From: Claire Potts <Claire.Potts@arun.gov.uk>
Sent: 17 October 2019 16:28
To: Planning.Responses <Planning.Responses@arun.gov.uk>
Subject: FW: BE/42/19/DOC Oldlands Farm
Importance: High

Details are now okay. Therefore I recommend that condition 25 is discharged based on RAM-0500-01A-DR-CR-10001 P04, RAM-0500-01A-DR-CR-10002 P02, RAM-0500-01A-DR-CR-10003 P01, RAM-0500-01A-DR-CR-10004 P02, RAM-0500-01A-DR-CR-10005 P02, RAM-0500-01A-DR-CR-10006 P01, RAM-0500-01A-DR-CR-10007 P02.

From: David Easton [<mailto:David.Easton@arun.gov.uk>]
Sent: 04 October 2019 09:58
To: Daniel Wheelwright
Cc: Claire Potts
Subject: BE/42/19/DOC Oldlands Farm

- DO NOT SCALE FROM THIS DRAWING.
- ALL DIMENSIONS ARE IN MM U.N.O.
- THIS DRAWING IS TO BE READ IN CONJUNCTION WITH ALL ARCHITECTS & ENGINEERS DRAWINGS & SPECIFICATIONS.
- MANHOLE TO BE CONSTRUCTED IN ACCORDANCE WITH WSCC STANDARD DETAIL S278/38/14 - VORTEX FLOW CONTROL

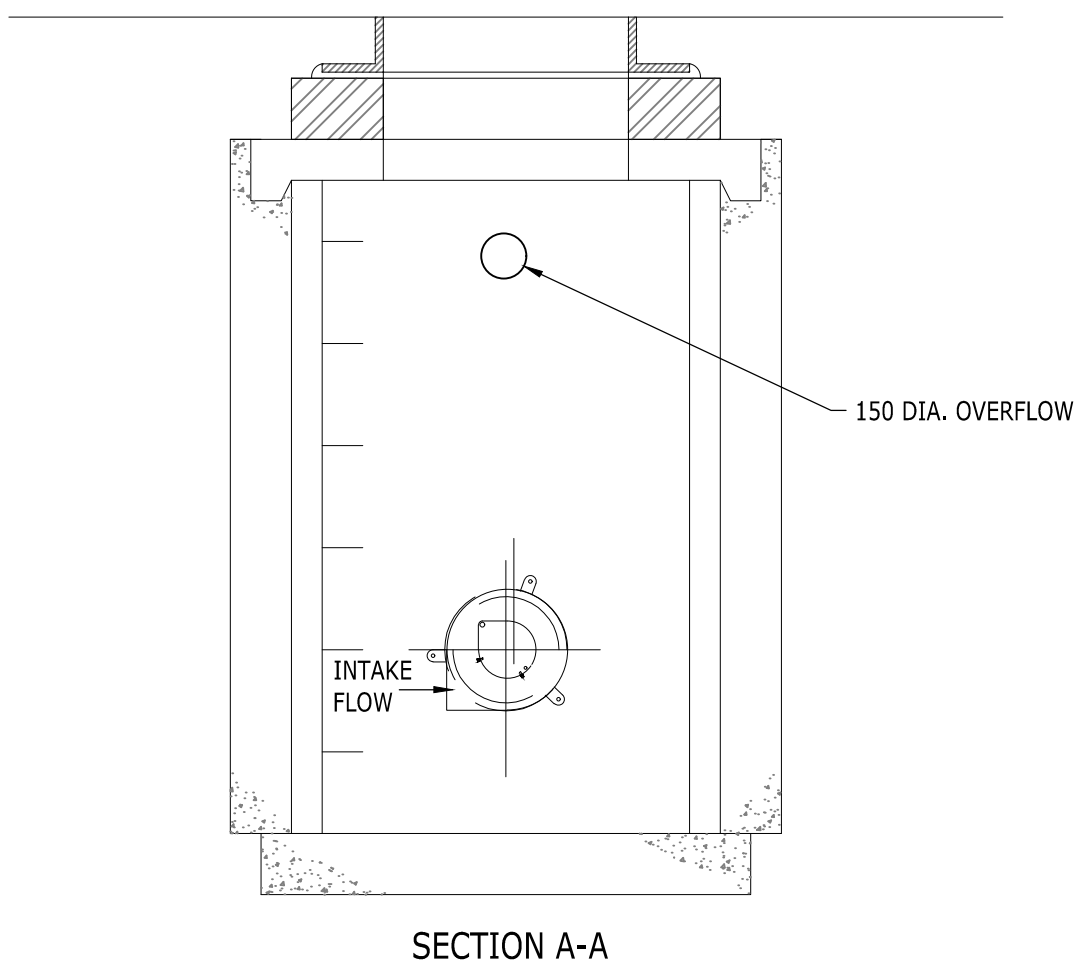
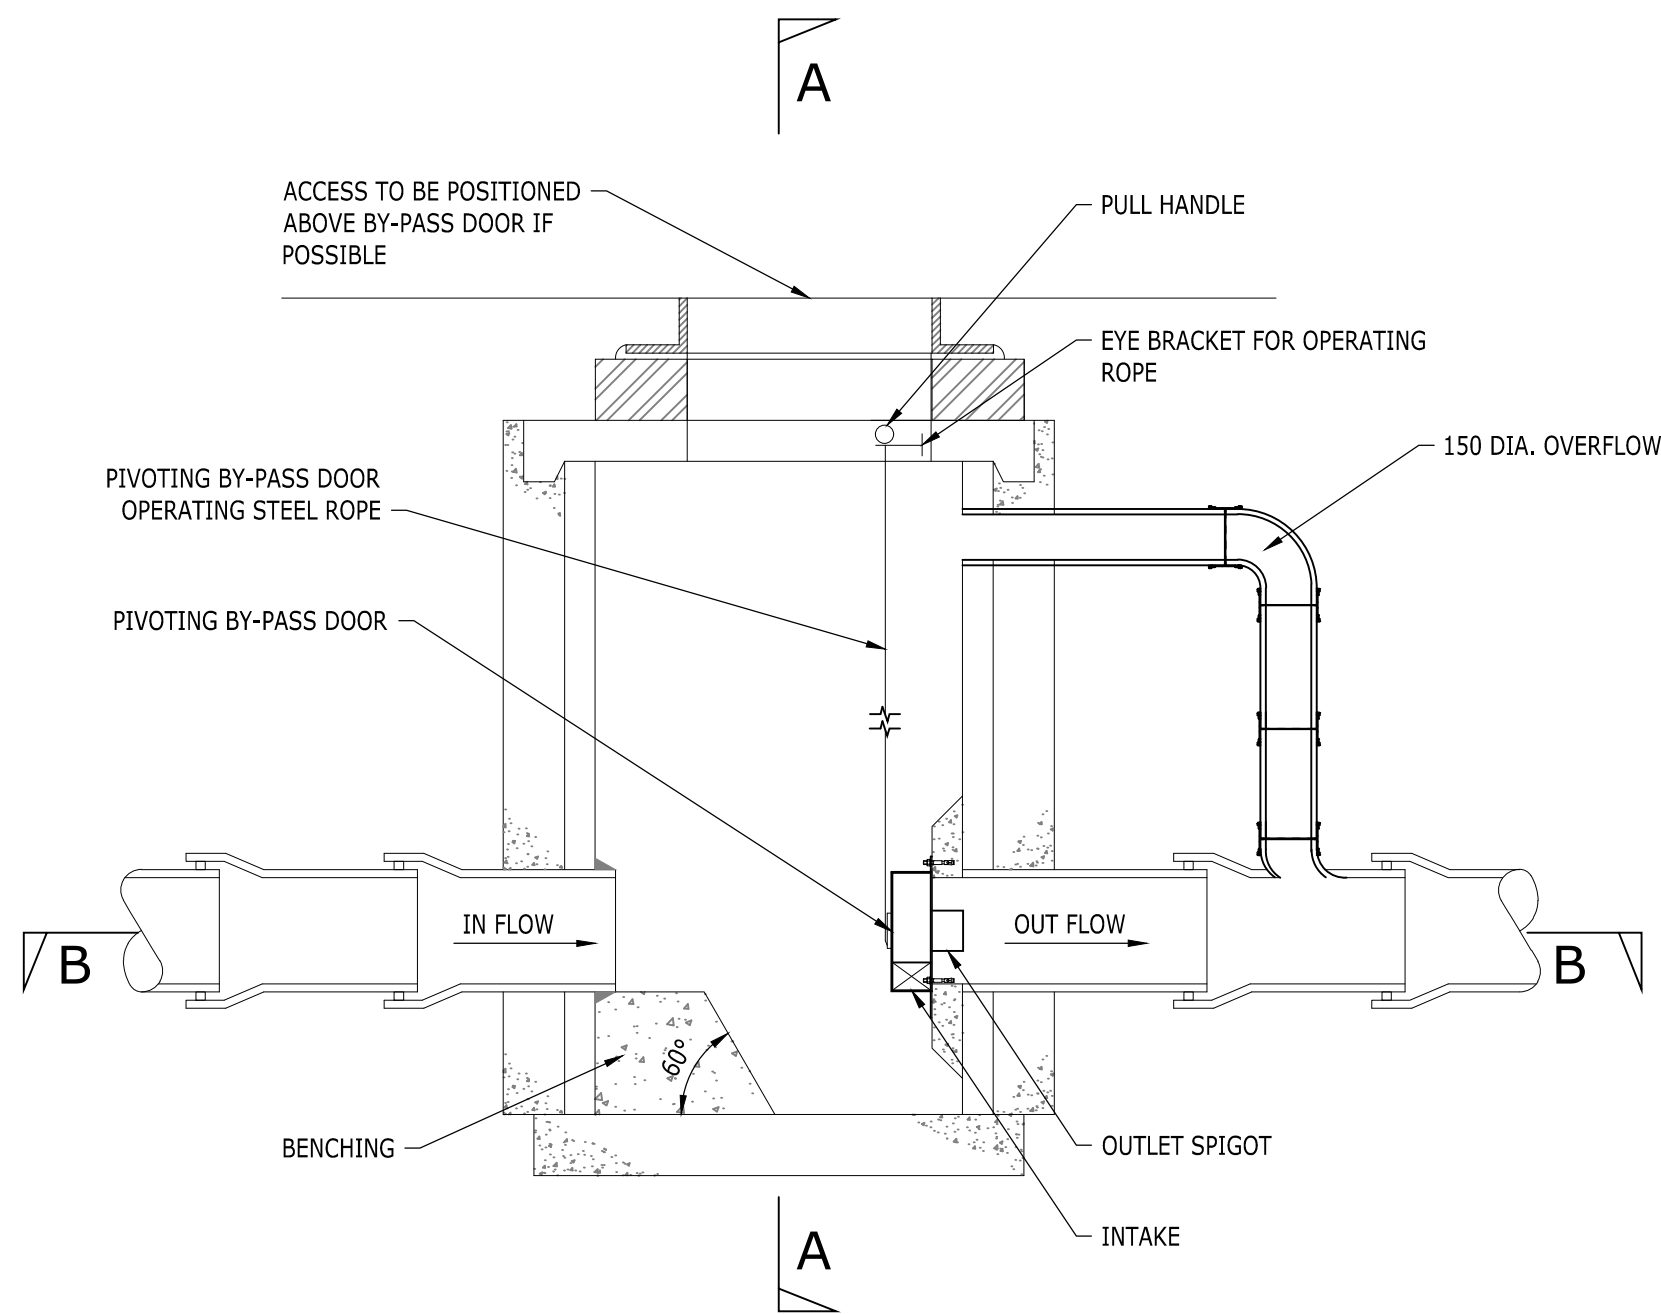
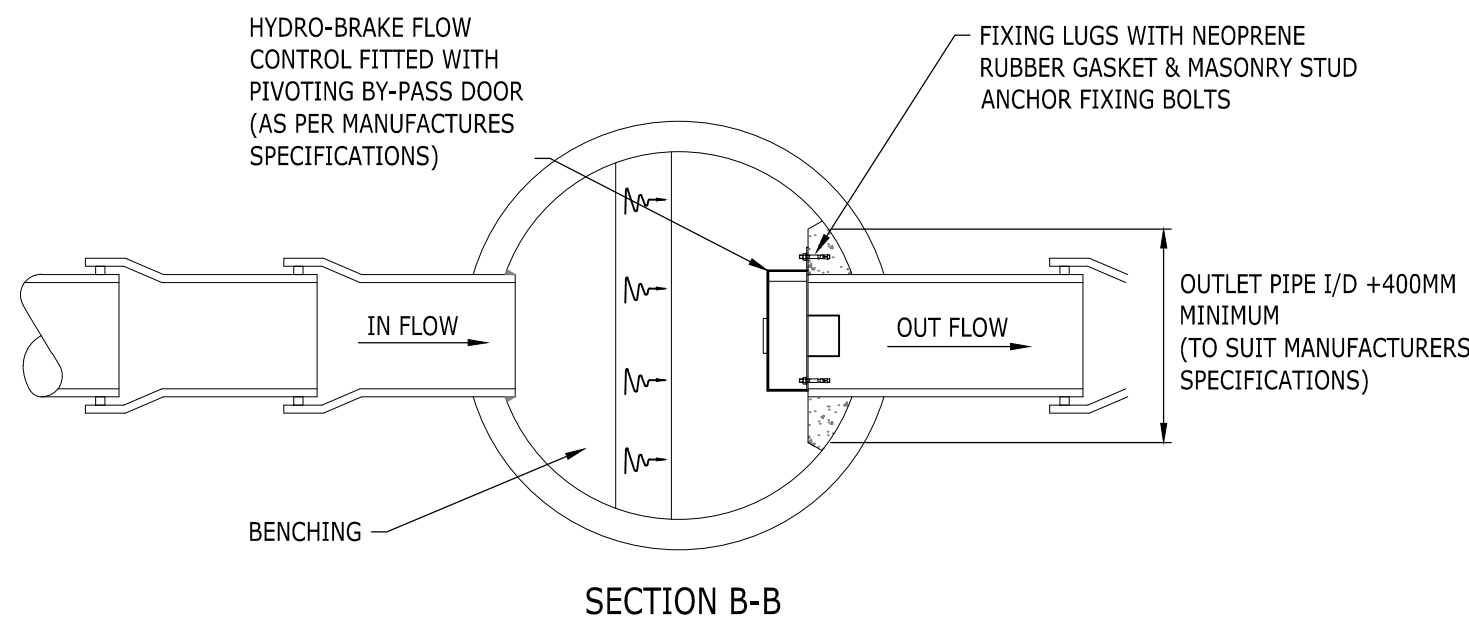
The overflow invert level proposed is lower than the 1 in 100 year plus climate change water level, therefore it would be coming into effect and letting flows out at greater than the permissible rate. Please can the applicant revise proposals so the overflow is above the 1 in 100 year plus climate change water level and include full details of the hydrobrake required on both layout and detail drawing. I.e. invert levels, cover levels, hydrobrake specification.

WSCC standard drawings are not sufficient. Please can the applicant provide site specific construction details, clearly indicating existing invert and cover levels and also whether an overflow is provided, and if so the invert level of this.

3. ~~Construction details for hydrobrake chambers need to be site specific as we need to review proposed elevations of overflows, etc.~~

~~Following remodelling no new hydrobrake chambers required, hence no detail required. Only the unit will need to be replaced in existing manhole to ensure restriction to 8.8l/s rather than 5l/s. No changes to existing manhole construction. Please provide as built detail then. As stated, we need to review elevations of overflows against calculations to ensure that flood risk is not being increased elsewhere.~~

Please see further amended drawings attached which provide the detail additional required by Laura. The overflow has been raised to be above the 1 in 100 +40% max water level (1.861m AoD).
